CITY OF ALBUQUERQUE

March 3, 2020

Re: Monterey Place Apartments
2306-2320 Central Avenue SW
Traffic Circulation Layout
Engineer's/Architect's Stamp 02-11-20

Based upon the information provided in your submittal received 02-13-20, the above referenced plan cannot be approved for Building Permit until the following comments are addressed:

## TRAFFIC CERTIFICATION

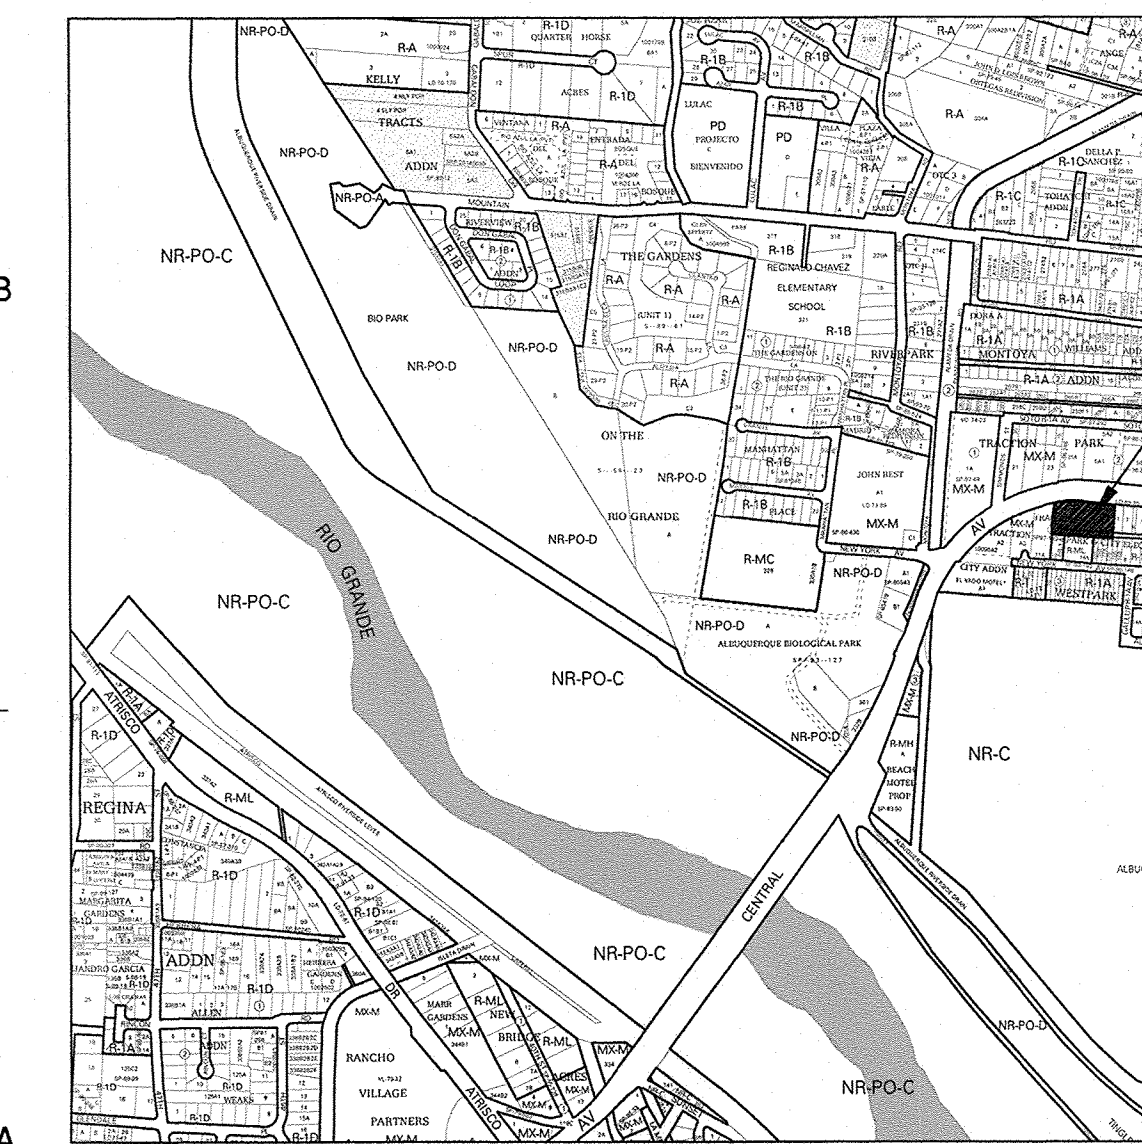
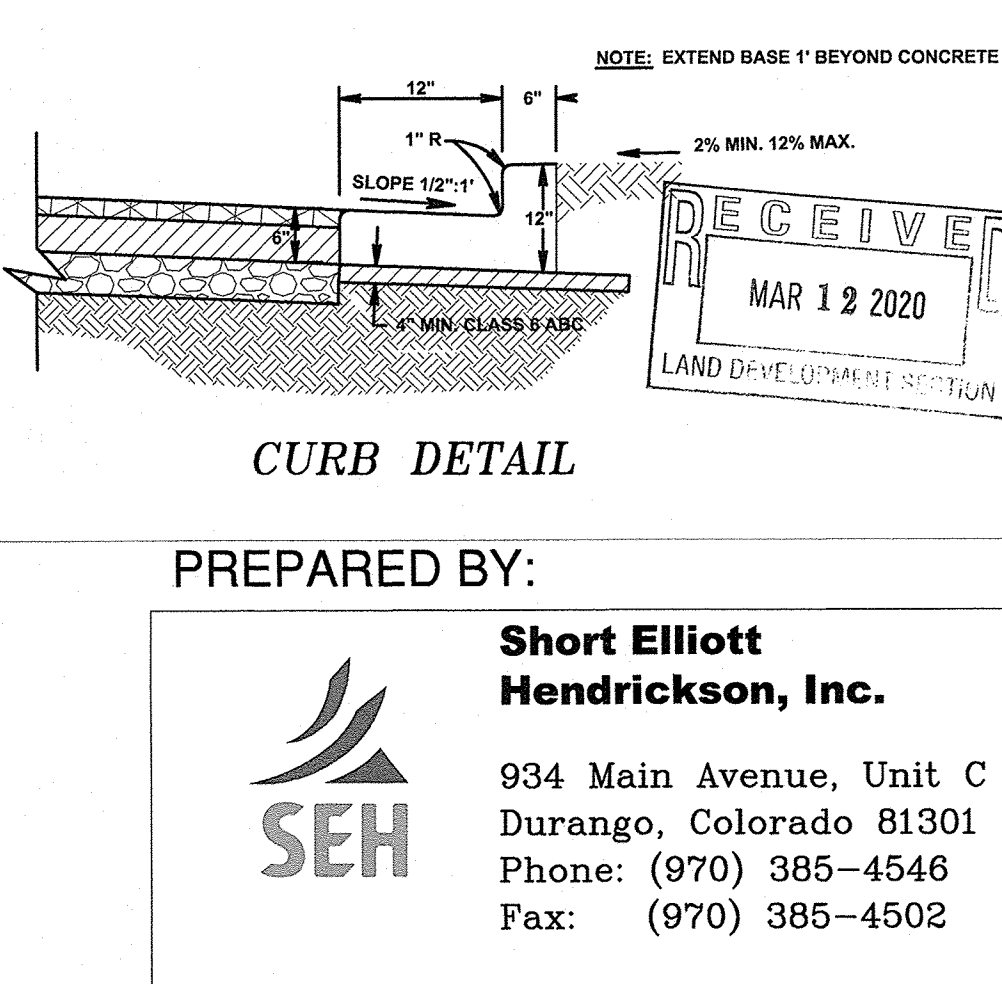
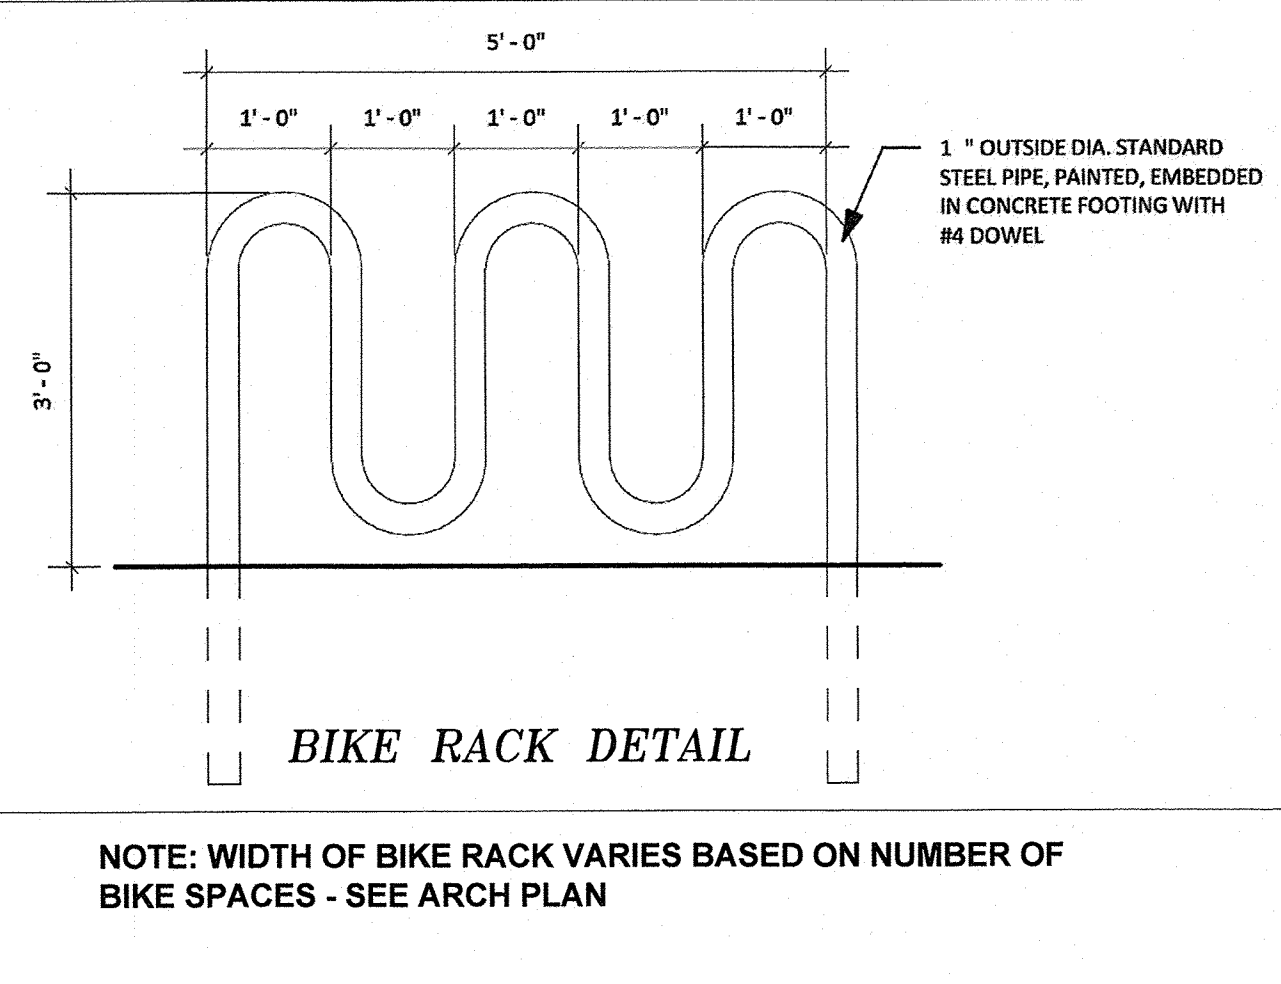
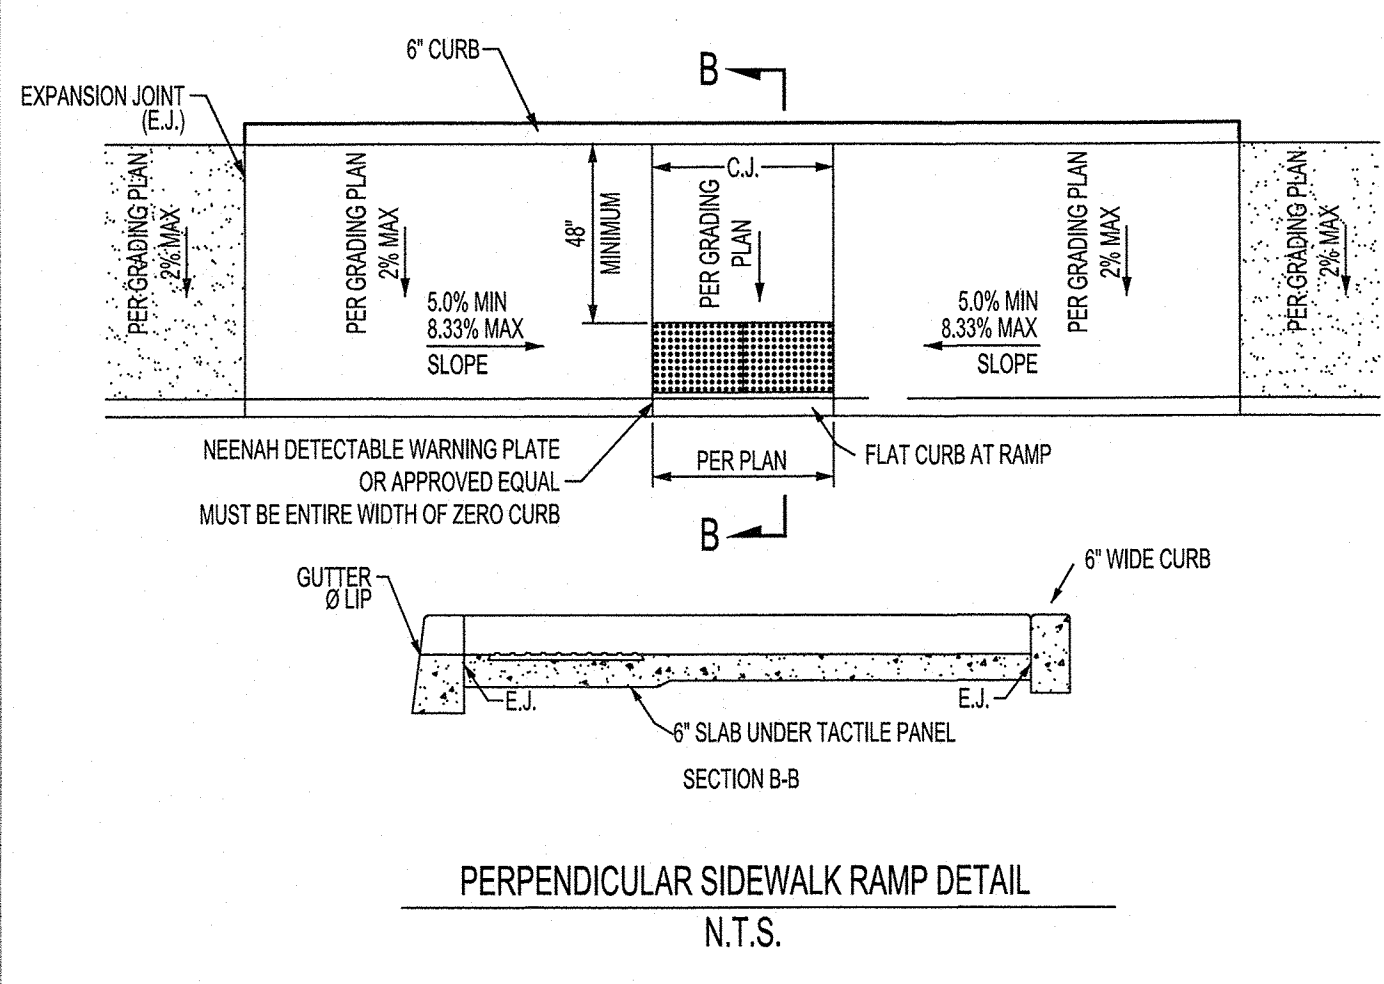
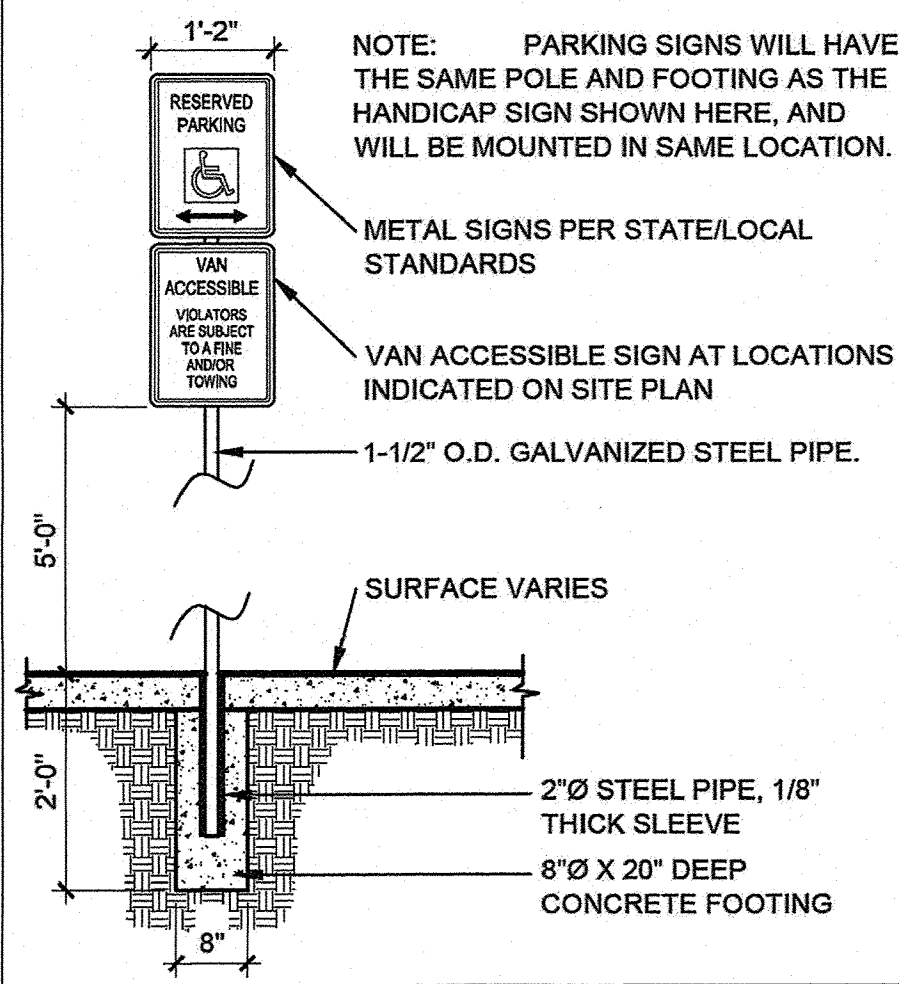
1. Please show a vicinity map showing the location of the development in relation to streets and well known landmarks.
2. Label any existing or proposed easements within the proposed development and access aisles.
3. Proposed number of parking spaces including bicycle and motorcycle parking need to be coordinated with Zoning to ensure compliance.
4. Please list the width and length for all proposed parking spaces. Some dimensions are not shown and provide landscaping buffer between curbing and sidewalk.
5. All proposed/existing entrance widths need to be shown on plans.
6. The minimum parking stall dimensions are:

7. The ADA accessible spaces must include an access aisle. Van accessible aisles should be 8ft wide; all others should be 5ft wide.

8. The ADA accessible parking sign must have the required language per 66-7-352.4C NMSA 1978 **"Violators Are Subject to a Fine and/or Towing."** Please call out detail and location of signs.

9. The ADA access aisles shall have the words **"NO PARKING"** in capital letters, each of which shall be at least one foot high and at least two inches wide, placed at the rear of the parking space so as to be close to where an adjacent vehicle's rear tire would be placed. (66-1-4.1.B NMSA 1978).

12. A detail of the water feature with ADA access crossings needs to be provided.
13. Motorcycle parking spaces shall be designated by its own conspicuously posted upright sign, either free-standing or wall mounted per the zoning code. Label MC on pavement of each space.

15. Bicycle racks shall be sturdy and anchored to a concrete pad. Show location of the bicycle racks.
16. A 1-foot clear zone around the bicycle parking stall shall be provided.

17. Bicycle parking spaces shall be at least 6 feet long and 2 feet wide.
18. Per the IDO, a 6 ft. wide ADA accessible pedestrian pathway is required from the public sidewalk to the building entrances. Please clearly show this pathway and provide details.

19. Per DPM, a 6 ft. wide ADA accessible pedestrian pathway is required from the ADA parking stall access aisles to the building entrances. Please clearly show this pathway and provide details.

20. Provide 8 ft. wide sidewalk when stalls are overhanging sidewalk. A solution would be to show parking bumpers on the south side parking stall.
